**From:** [REDACTED]  
**To:** [Aquind Interconnector](#)  
**Subject:** you will not build the aquind interconnector through portsmouth  
**Date:** 21 October 2020 22:31:21

as an "Affected Person" i wish to tell you that you cannot possibly lay your interconnector through portsmouth. why you have chosen to go through the most densely populated city in northern europe is ridiculous. the disruption it would cause would be immeasurable. also portsmouth is an island with only three bridges on and off the island so building works would cause gridlock.

Compulsory Aquisition Hearing 1 – Appendix 1
- Exhibit 15 Cross-section showing the typical
arrangement of the construction corridor
across Milton Common

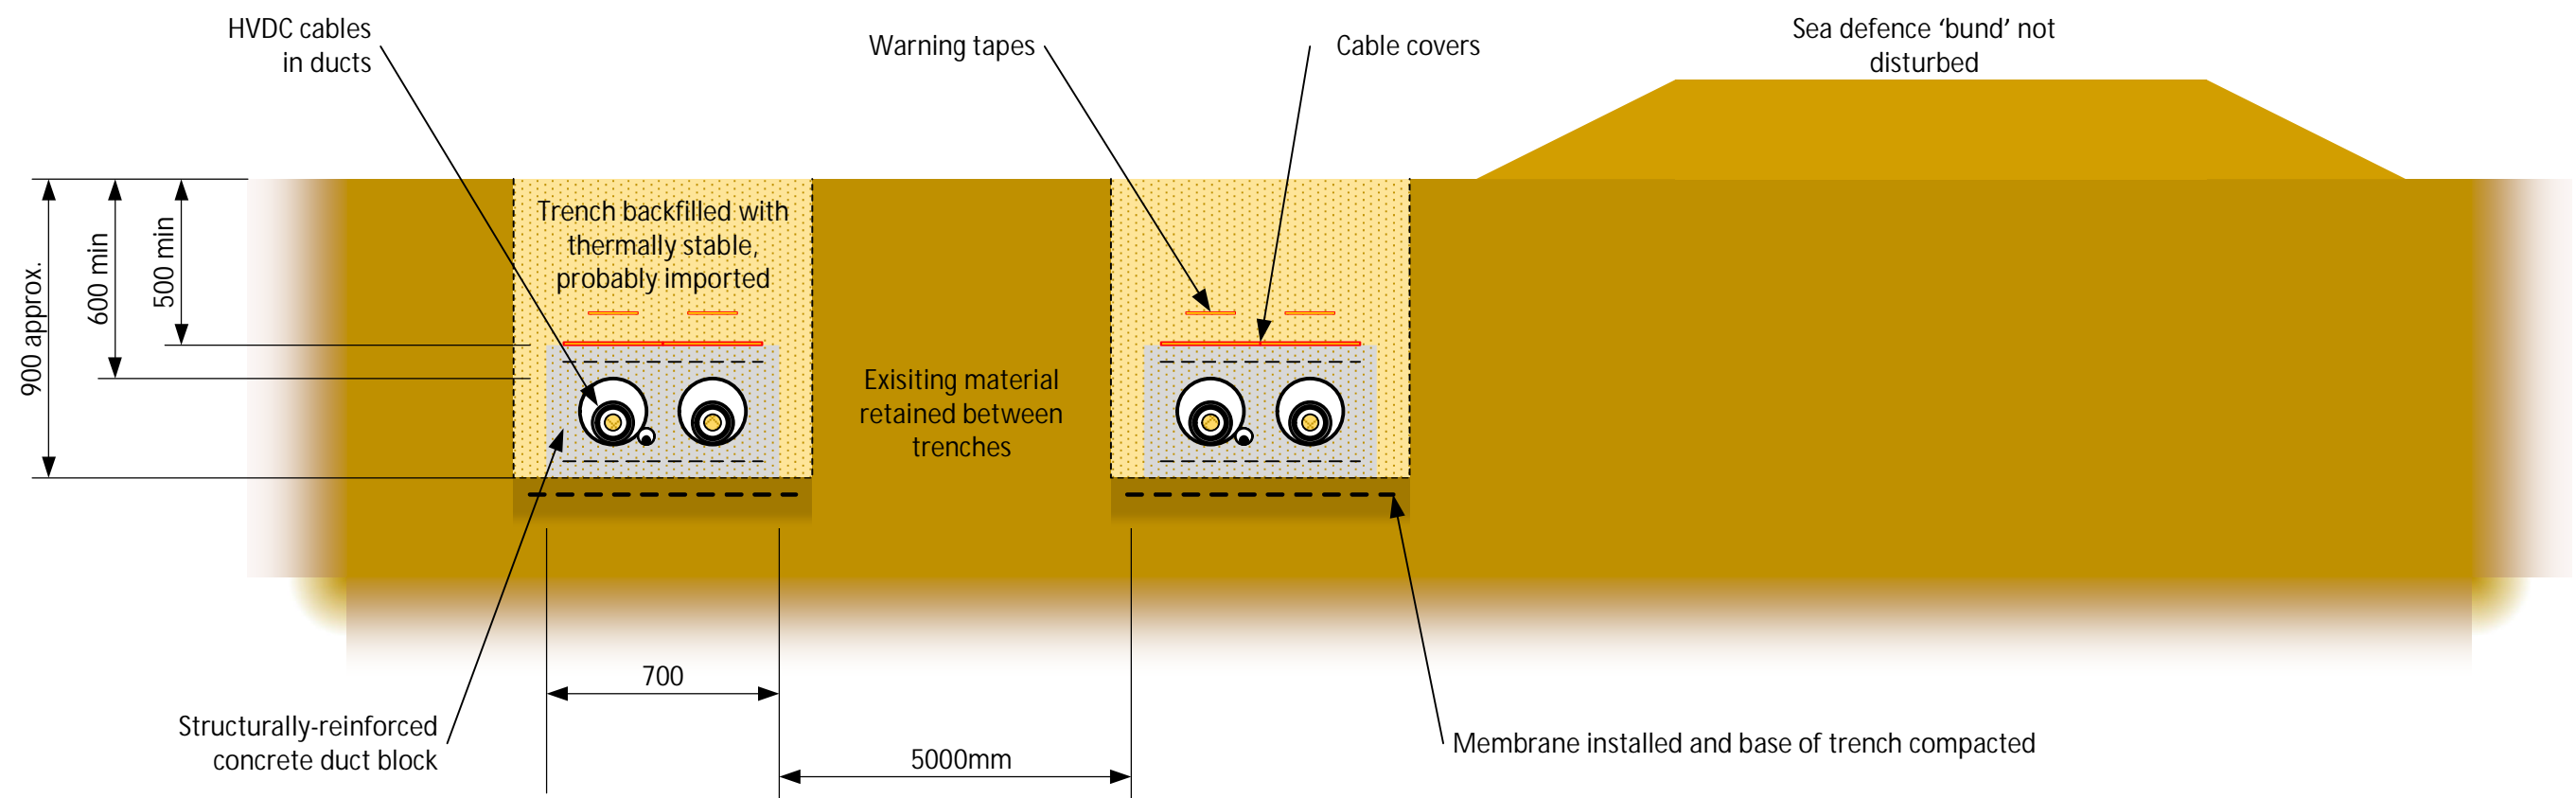
the plans show running under milton common. the planners obviously do not know that this area is on top of what was a rubbish dump/landfill sight. this creates methane. the area has beneath its surface has protective membrane to contain this explosive gas. so aquind cannot lay cables in this area.
